Office of
Environment
& Heritage

DOC17/367057-3
DA 49/94 Mod 9 & DA 08_0102 Mod 7

Rix's Creek - (DA 49/94 Mod 9) and Rix's Creek North (DA 08_0102 Mod 7)

ATTACHMENT A: OEH REVIEW OF THE PROPOSED MODIFICATIONS TO THE RIX'S CREEK MINING OPERATIONS (DA 49/94 MOD 9 & DA 08 0102 MOD 7)

APPENDIX 3A: MOD 7 EXPLORATION DRILLING PROGRAM

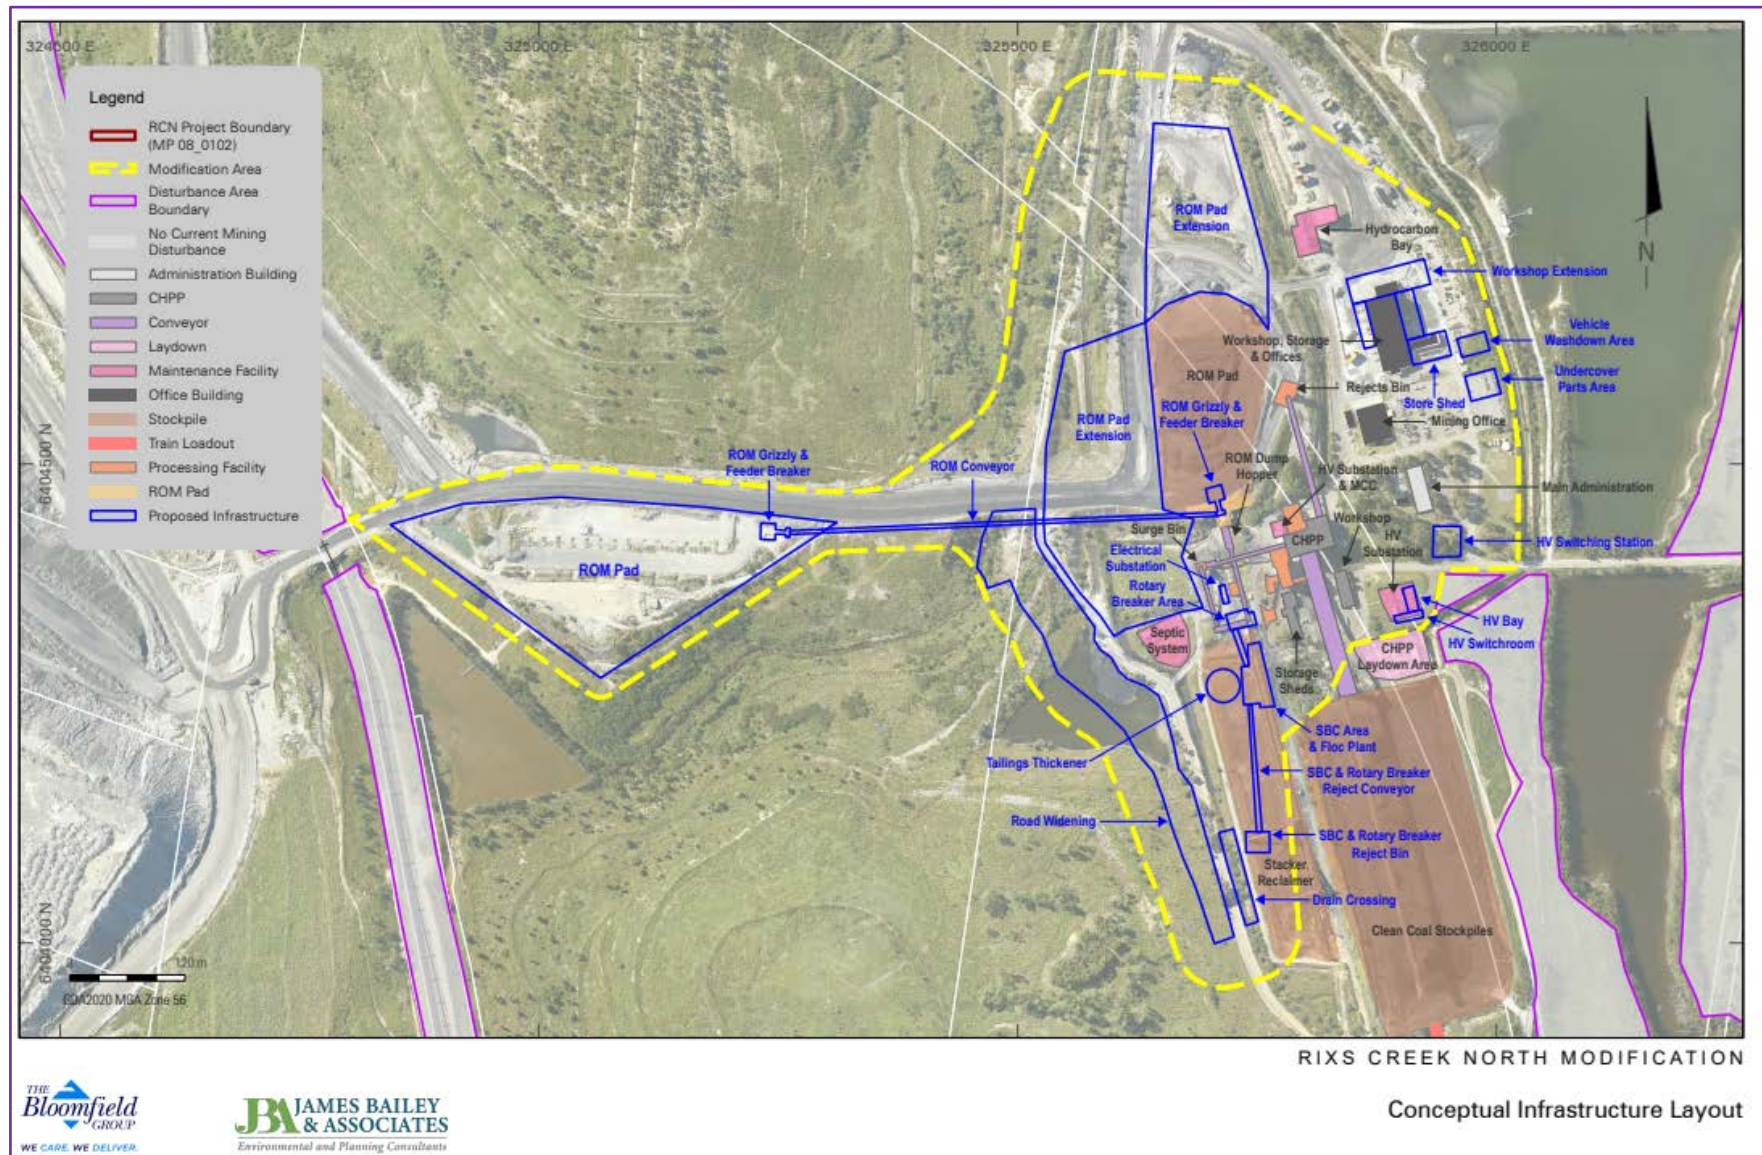
OEH reviewed the ecological assessment of the drill hole exploration area (Forest Fauna Surveys Pty Ltd & Eastcoast Flora Survey, 2017). The largest potential impact on threatened biodiversity is from the ca. 400m² of clearing around each of the eight proposed drill holes and the access roads between them. This would clear or disturb <0.5 ha of vegetation that meets the definition of *Central Hunter Grey Box-Ironbark Woodland in the New South Wales North Coast and Sydney Basin Bioregions Endangered Ecological Community* (EEC). The area also contains habitat for several threatened species, such as Squirrel Gliders (URS, 2009).

The ecological assessment was based on previous survey work and a site inspection of each drill hole location conducted on 13 June 2017. No formal vegetation quadrats appear to have been conducted. The site inspection included consideration for *Diuris tricolor*, which would have been in leaf on the day of survey but is only identifiable when it flowers in September and October. The EA concluded that the proposed activities may clear <0.5 ha of EEC vegetation, that none of the drill hole sites would likely support threatened species, and that the proposed works would be unlikely to have a significant impact on threatened biodiversity. No offset was proposed. Instead drill hole locations are to be preferentially located on cleared land to minimise impacts on environment. Any soil removed to prepare the site will be stockpiled and returned to the site. Rehabilitation outcomes for the site are stated as being to return each site to a safe and stable state that allows for the current land use. Future monitoring is planned with the scope for remedial action to ensure that long-term outcomes for each site are achieved. However, those long-term objectives do not appear to be stated in the EA.

1. The areas of proposed disturbance must be surveyed for *Diuris tricolor* during its known flowering time (mid-September to mid-October) prior to any works being undertaken, utilising at least one reference population in the Hunter Valley (e.g. Thomas Mitchell Drive population) as a guide to the suitability of survey time. Any plants found must either be avoided or, if harmed, then appropriately offset (e.g. retiring appropriate biodiversity 'species credits').

2. Areas disturbed by proposed exploration drilling must be rehabilitated within 12 months after exploration works have been completed.
3. In areas, where any trees > 2 m tall are cleared for exploration works, the same species of tree must be put back in the disturbed area in at least a 2:1 ratio. Those new trees must be established within 12 months of the completion of works, with any losses being replaced.
